City of Albuquerque

RE: ENGINEER'S CERTIFICATION FOR ISSHIN RYU KARATE CLUB (L-14/D041)
ENGINEER'S STAMP DATED MAY 5, 2000, CERTIFICATION DATED 21, 2000.

Re: T.C.L. submittal for building permit approval for Isshin Ryu Karate Center,
1314 Gibson S.E., Lands of Hugh B. Woodward, Tracts A & B, [L15/ D041],
Engineer's Stamp dated 7/12/2000.

RE: DRAINAGE PLAN FOR ISSHIN RYU KARATE CLUB (L15-D41)
ENGINEER'S STAMP DATED 4/28/94.

CITY OF ALBUQUERQUE
PARKS / GENERAL SERVICES
DESIGN & DEVELOPMENT
TITLE: ISSHIN RYU KARATE CLUB
GRADING/DRAINAGE PLAN

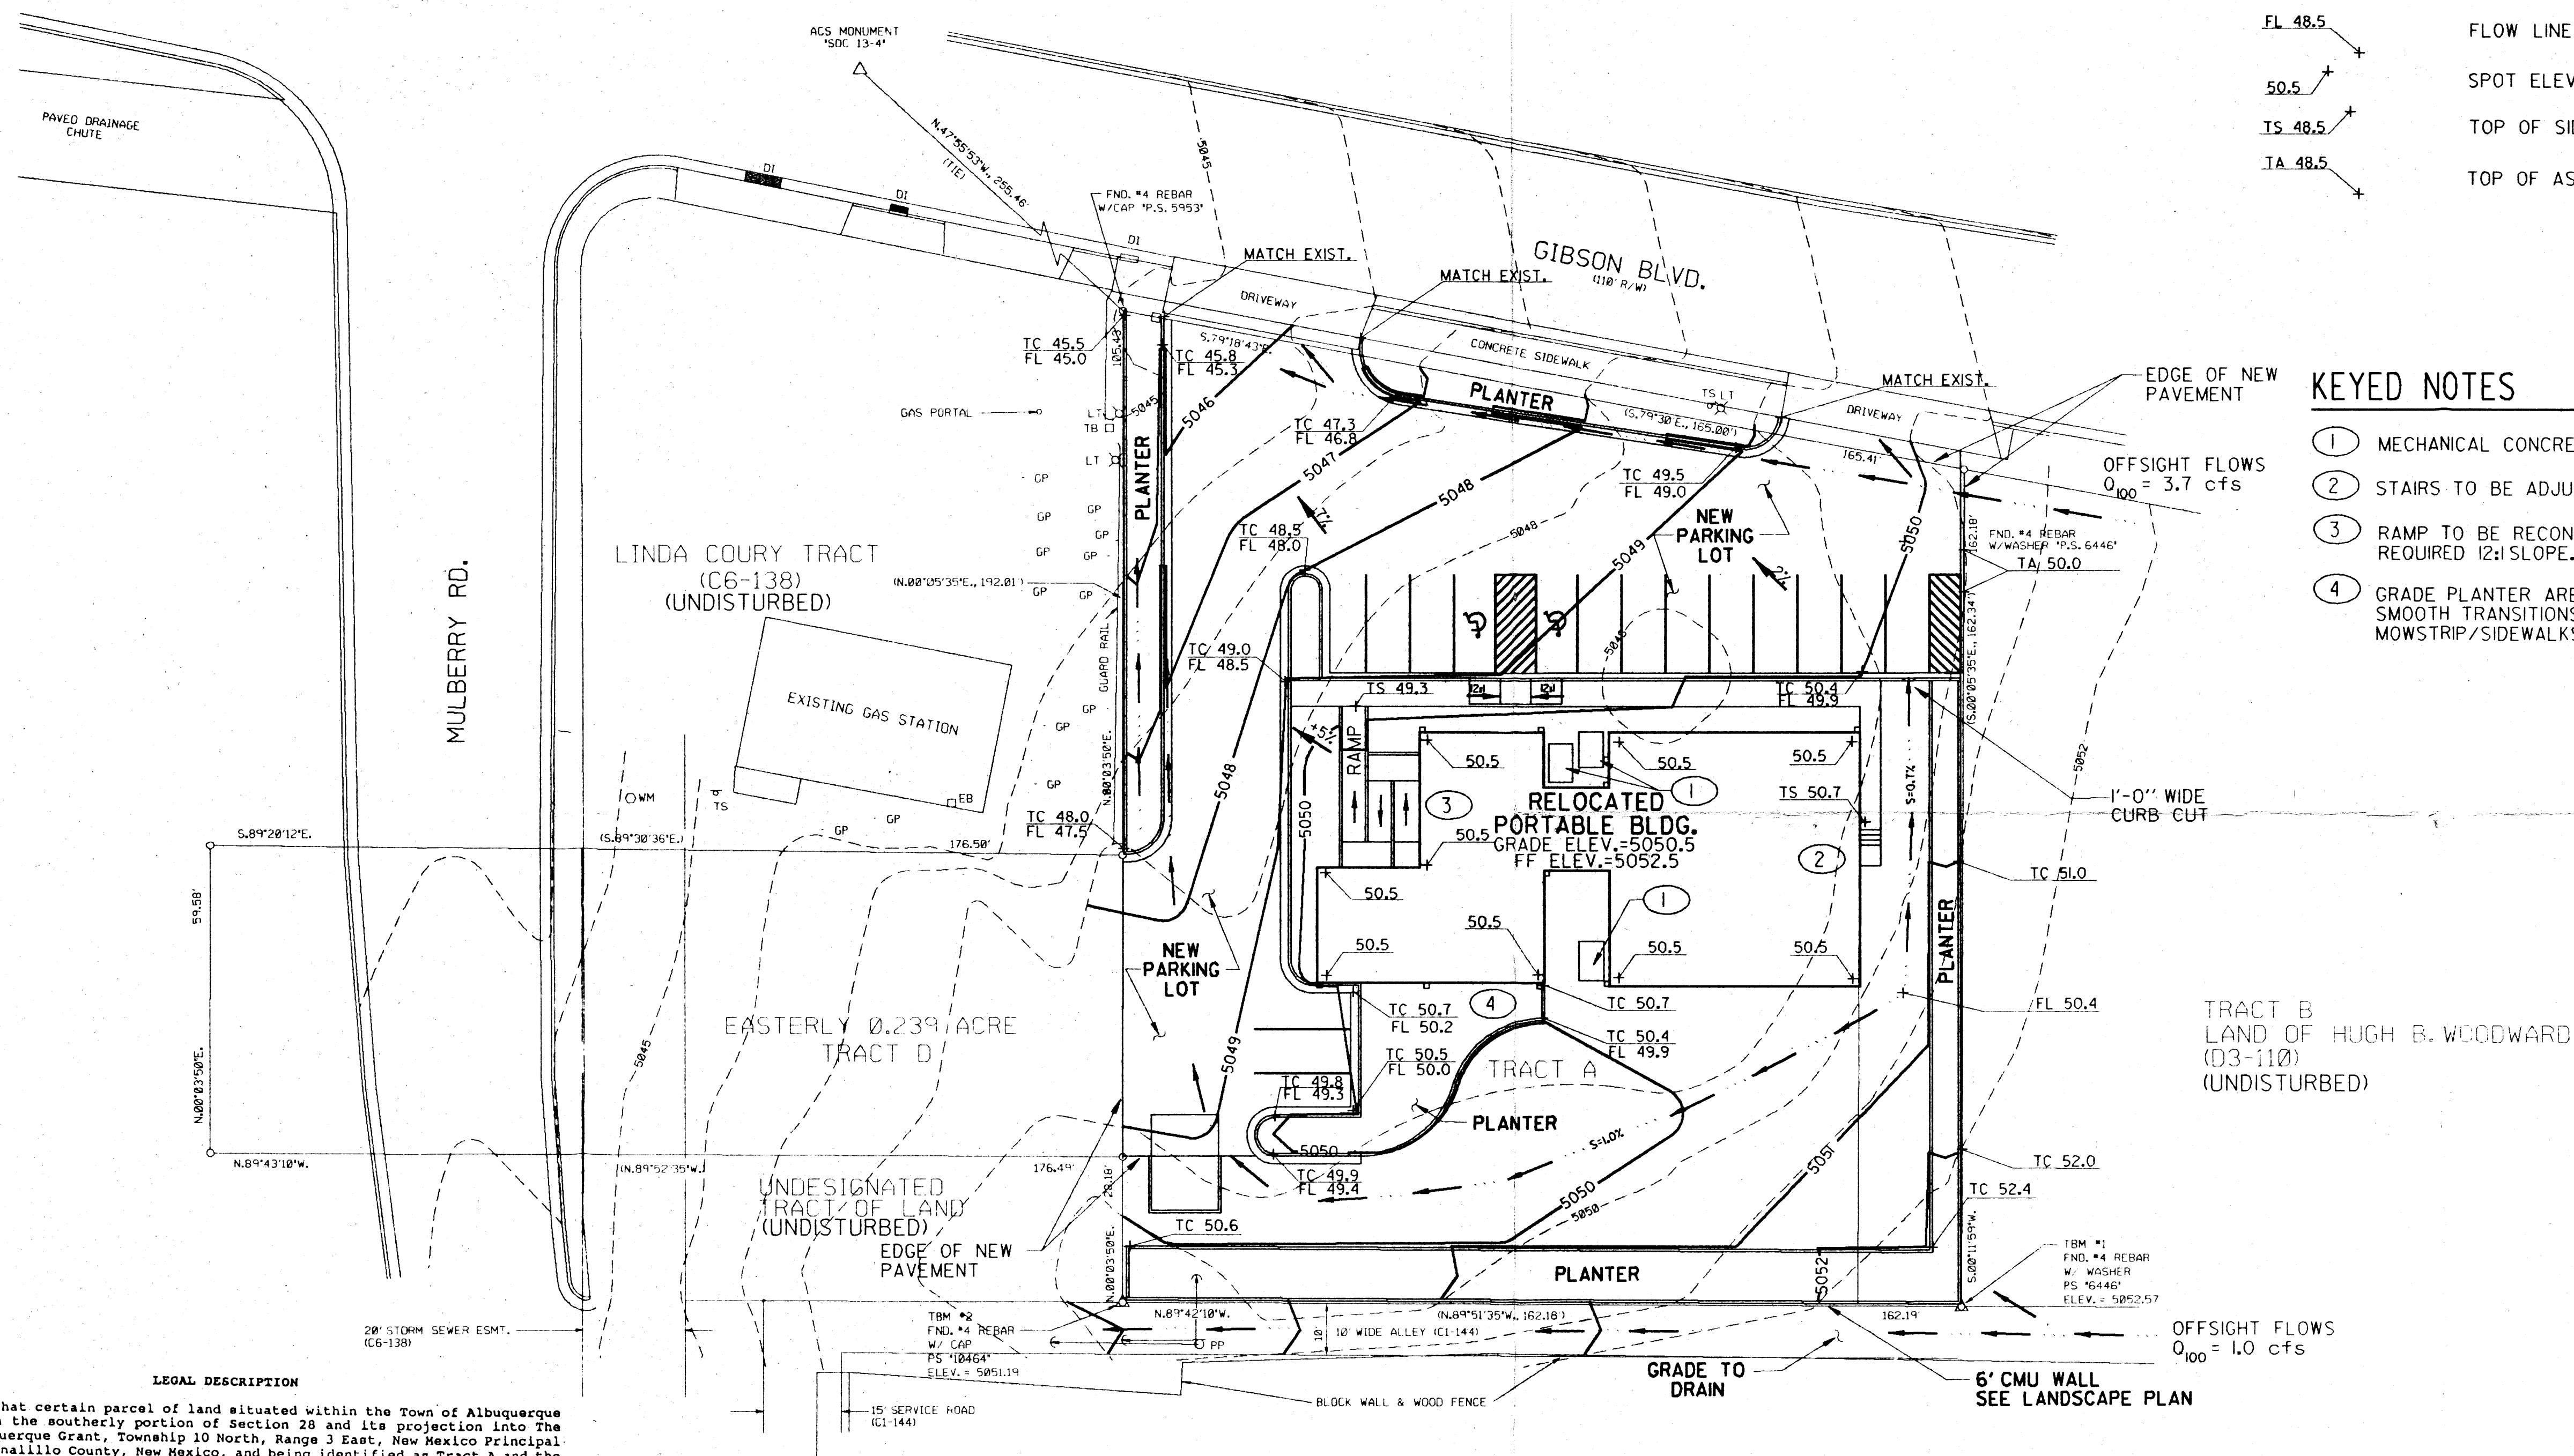
1. All the developed run-off from Tract A must be contained within the tract and routed towards the existing drivepad.
2. Permission from the owner of Tract B to grade on their property is required.
3. You must take into consideration that you have almost 4.7 cfs of offsite flows entering the site. With the slope given will the on-site and off-site flows be able to turn north onto the drivepad? If not, provisions must be made to trap the flows before they go into Tract D.
4. T.B.M. on site must be shown and permanently marked.

TRAFFIC CIRCULATION LAYOUT
APPROVED

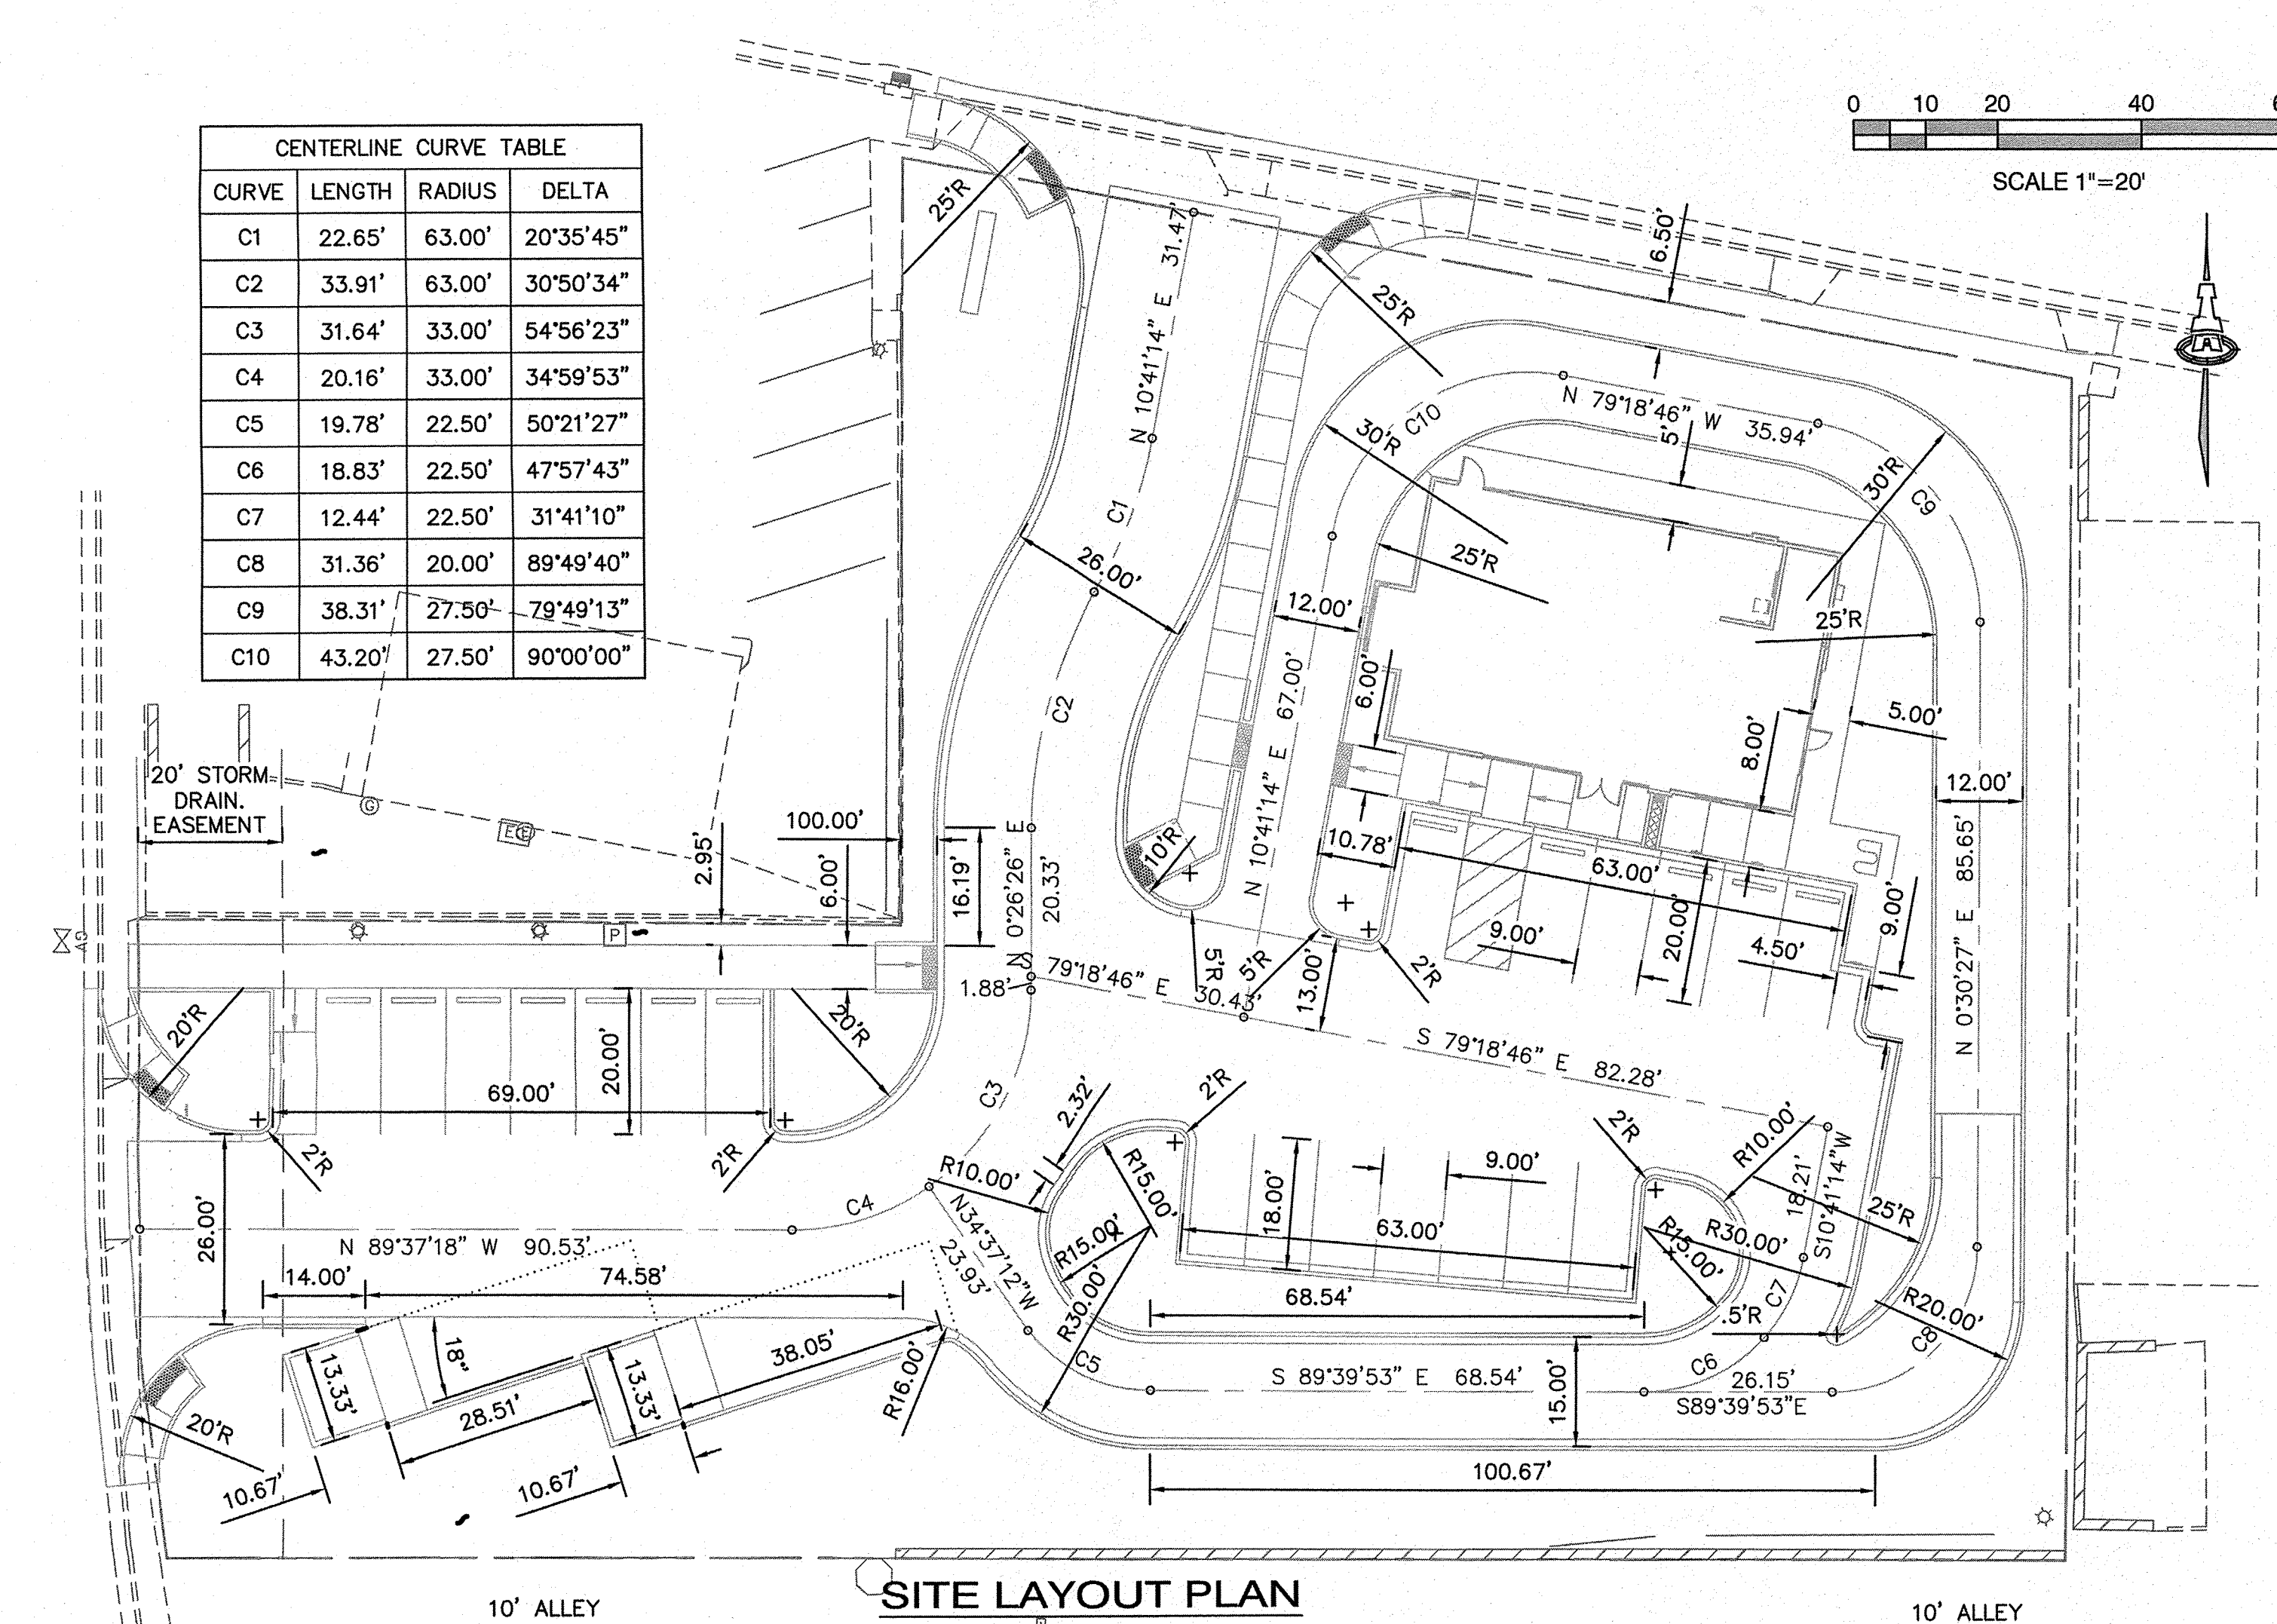
- All TCL's must be at Engineer's scale, 1" = 20' is preferable.
- Place a note on the plan stating the following:
 "An as-built copy of the approved TCL (Traffic Circulation Layout) must be submitted by the designer-of-record, as required by Transportation Development, including a letter of certification that the site has been constructed in accordance with the TCL. Verification of TCL acceptability, (including random field checks) will be made before a Final Certificate of Occupancy is issued." Please call this office to obtain temporary C.O.

- Existing street sidewalk and C&G affecting safe vehicular or pedestrian travel will be removed and replaced. Note on TCL if conditions are not field verified.

- Show, label, and dimension existing and/or new street sidewalk[s]. City sidewalk ordinance requires minim. 4' street sidewalks along the frontage of all commercial sites being developed.

- Label - Construct new drivepad "per City of Albuquerque Std. Detail Dwg. No. 2425." - at each location or as general note [if not on Drainage/Grading Plan]. _Drivepad to be constructed to Right-of-way line. __Drivepads will need improvement per D.P.M. and City of Albuquerque Std.DetailDwg[s].No. 2425.

- Show and label right-of-way line on Mulberry.
- Need to see that all existing obstacles in City right-of-way, in existing sidewalks, have been picked up.
